STATUTORY PLANNING CONSULTATION RESPONSE

Application Number:	3/2026/0214
Proposal:	Proposed erection of 26 affordable dwellings with associated access, gardens, parking and landscaping.
Location:	Land at Albany Drive Copster Green BB1 9EH

Objection 01 – Inadequate Surface Water Sustainable Drainage Strategy

Drawing file: planx_downloads / 26_0214_25358002C_Amended_Impermeable_Area_Flood_Route_Plan_24Jul26.pdf

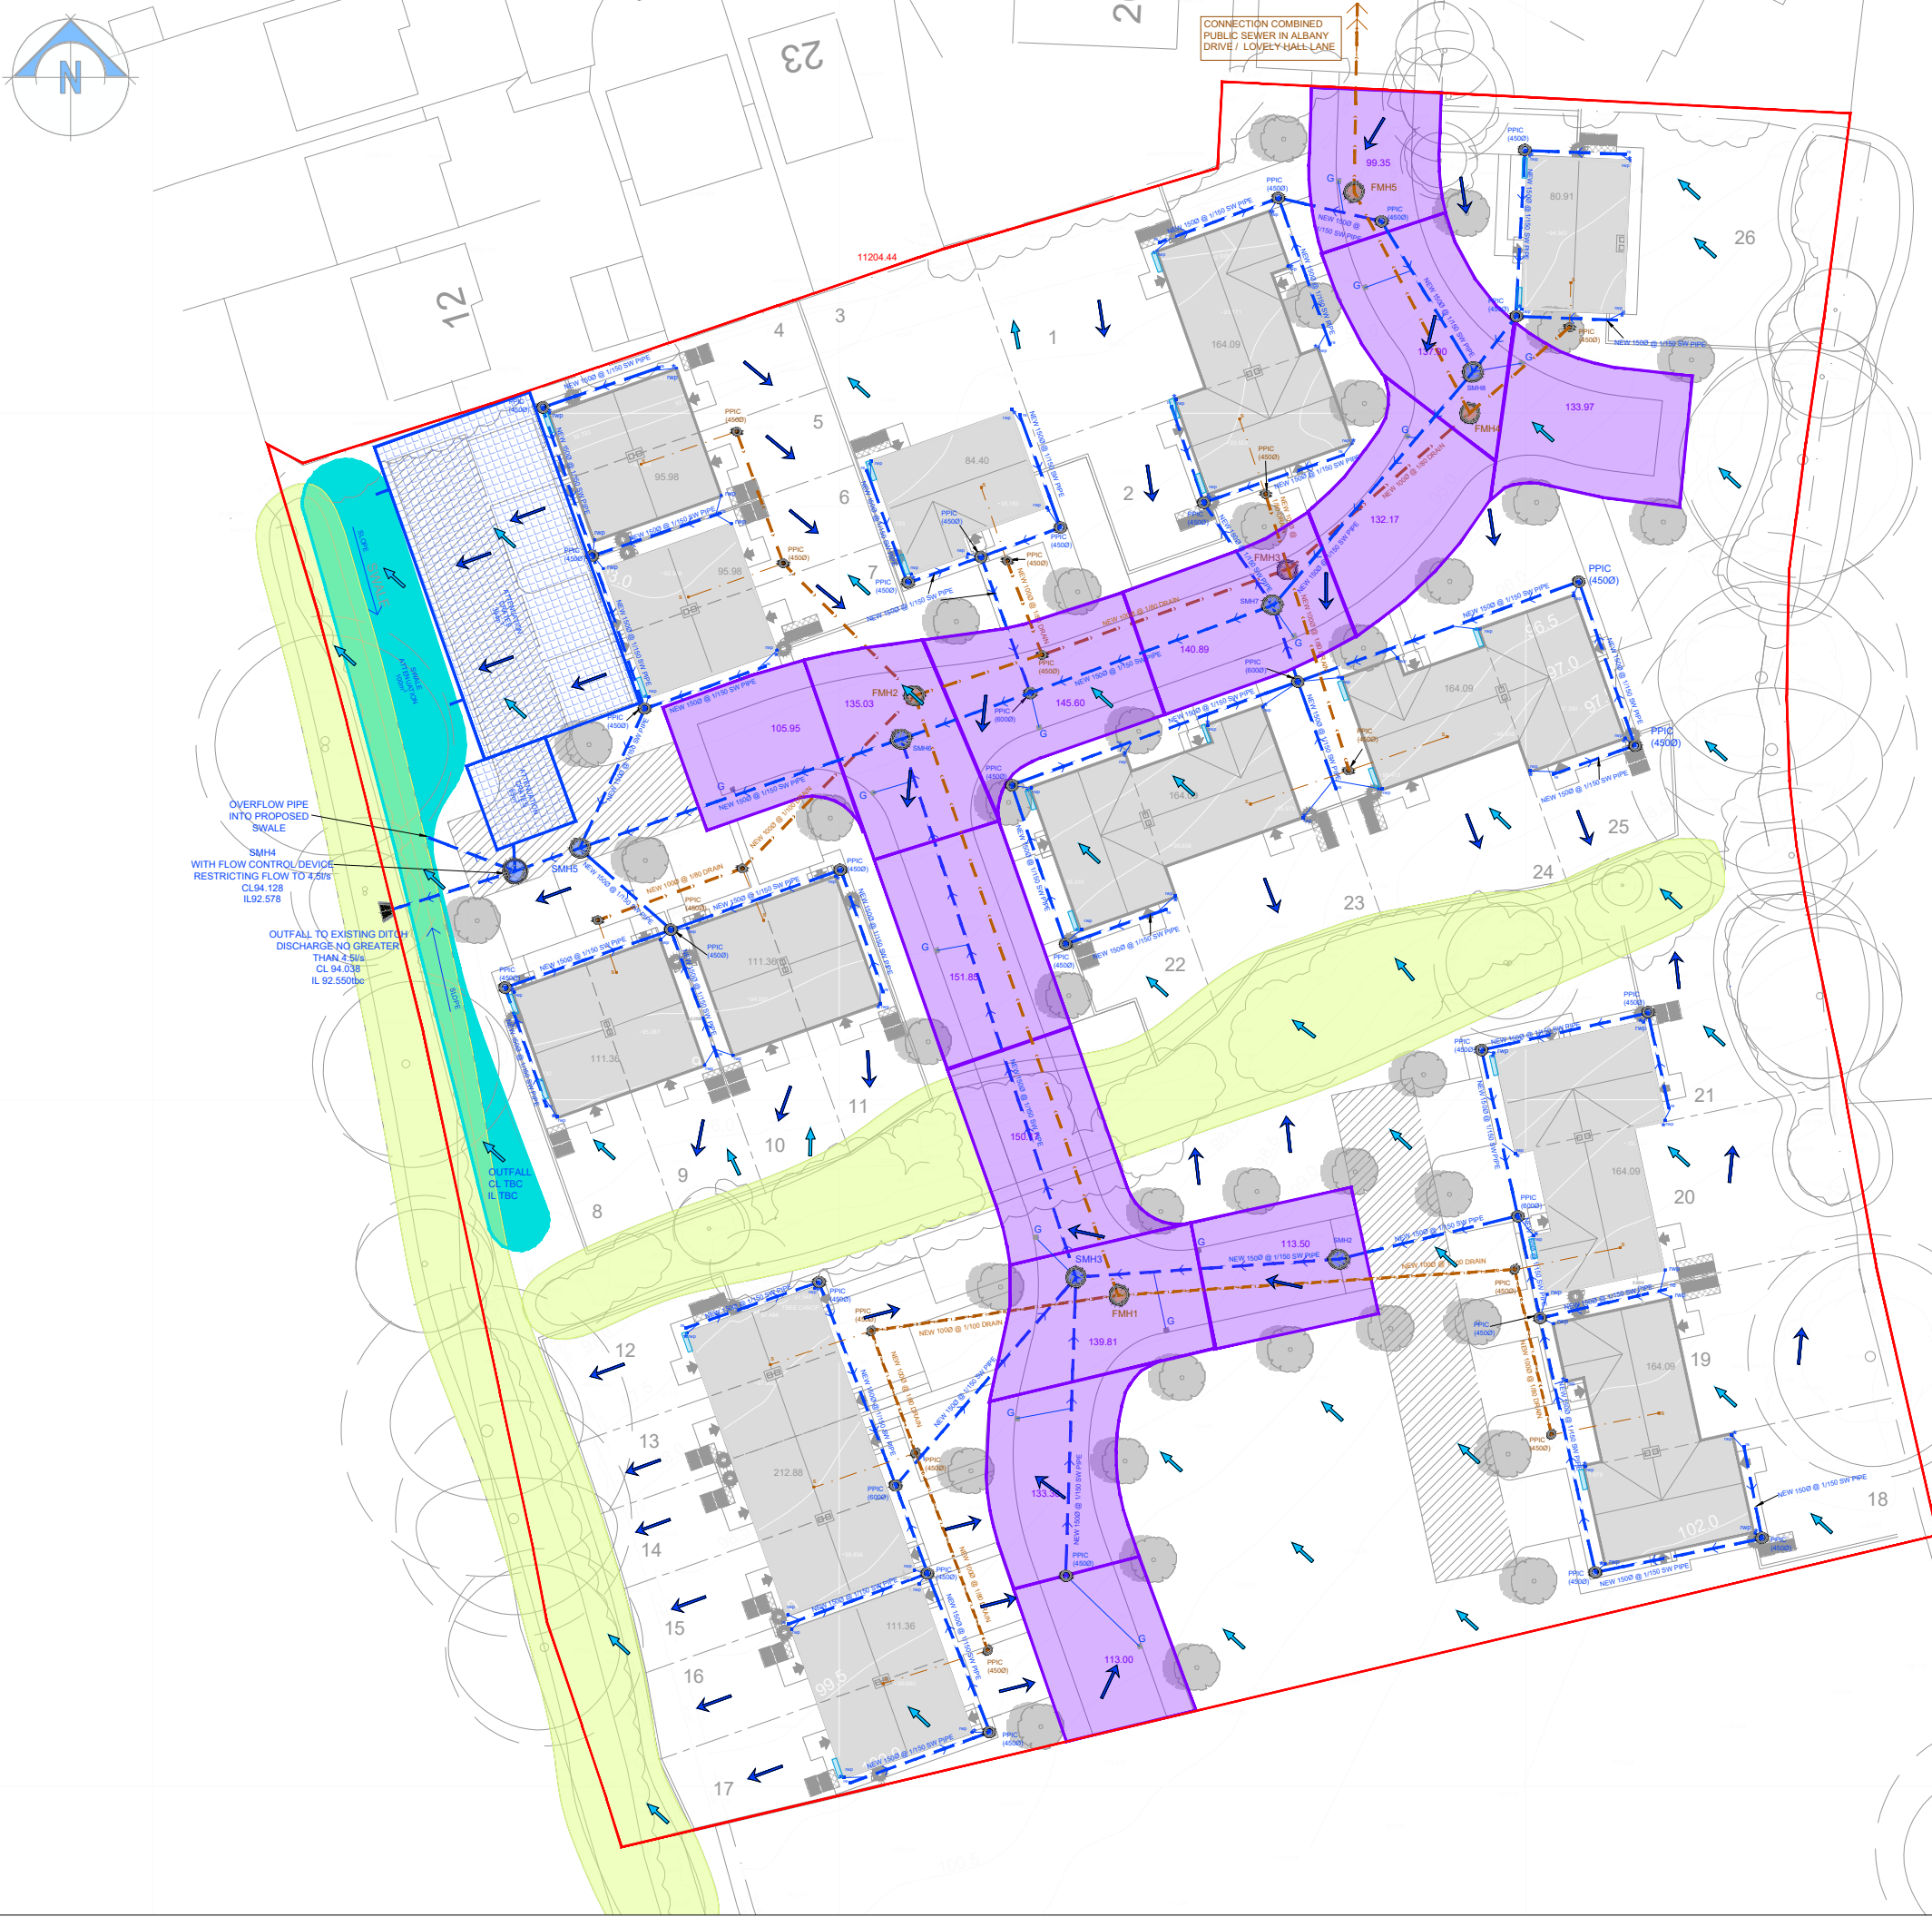
1. **Inconsistent contributing area to size the SuDS** – The proposed drainage strategy fails to demonstrate compliance with Standard 3 of the National Standards for Sustainable Drainage Systems.

The submitted drainage strategy sizes the SuDS based only on the impermeable area of the site (approximately 0.562 ha), excluding the remaining permeable areas of the site, but calculates the discharge rate (9l/s) based on the approximate full 1.120 ha site area. Standard 3 requires that the entire development area that could potentially drain to the proposed surface water drainage system in an extreme

event shall be used for estimating greenfield runoff rates and volumes (including both permeable and impermeable surfaces). For the avoidance of doubt, the runoff area used in any of the runoff estimation methods should be consistent.

The applicant must design their SuDS with an appropriate estimation of the area contributing to the drainage system, both permeable and impermeable, with evidence of this area provided through an appropriate contributing area plan, or otherwise demonstrate how surface water runoff from non-drained areas will be managed without contributing to the drainage system and without increasing flood risk onsite or elsewhere.
